CITY OF ALBUQUERQUE

PLANNING DEPARTMENT – Development Review Services

**RE: Marie Hughes Elementary School – 2701 Mojave Street, NW
Grading Plan for Work Order
Engineer's Stamp Date 6-26-2015 (D11D7)**

C101

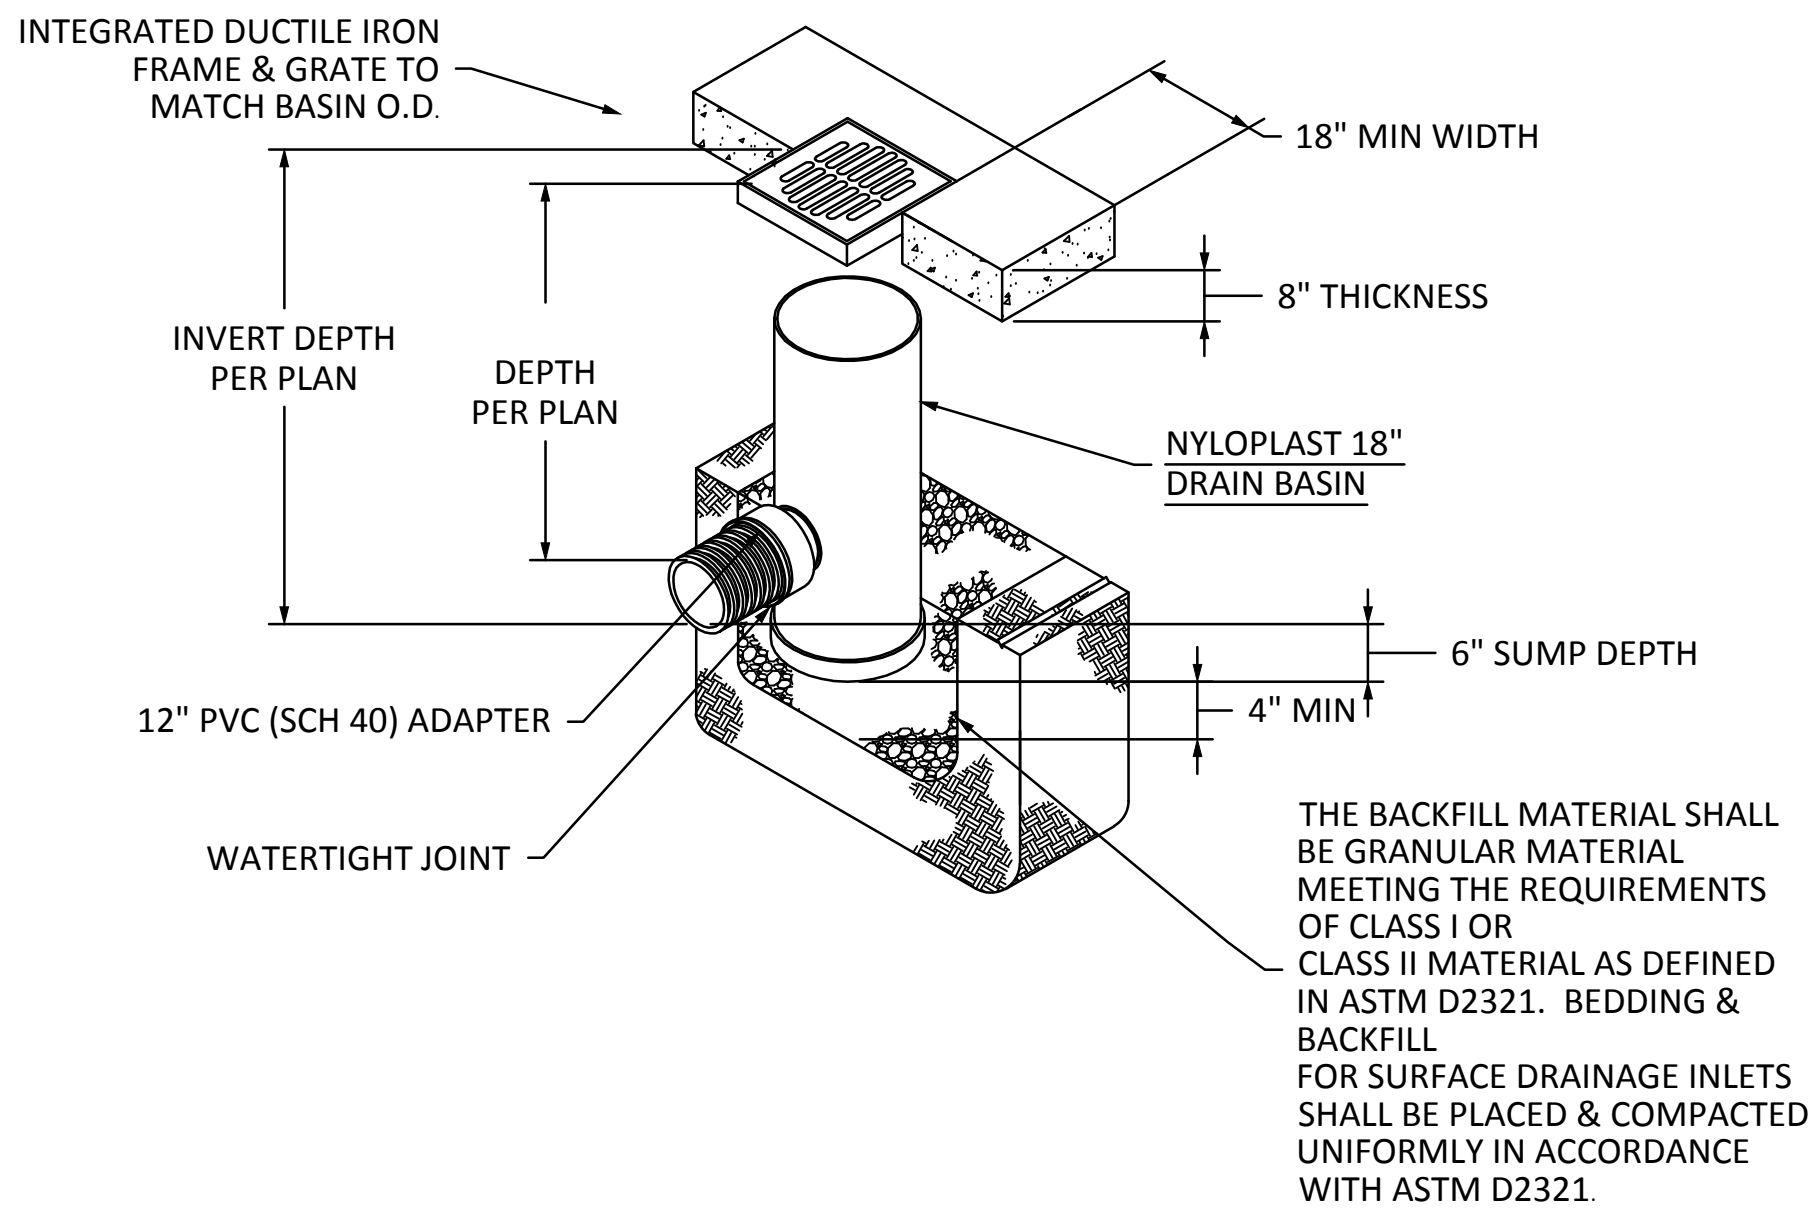
The older plan by JMA in 1995 states that the outfall for this site was the Mariposa Diversion Channel, but no clear outfall to the channel is shown on the plan. Therefore it is not clear if discharging to the street is the historical discharge point or not. For Building Permit approval either show that this site historically discharged to the street or show that the inlets and street have sufficient capacity.
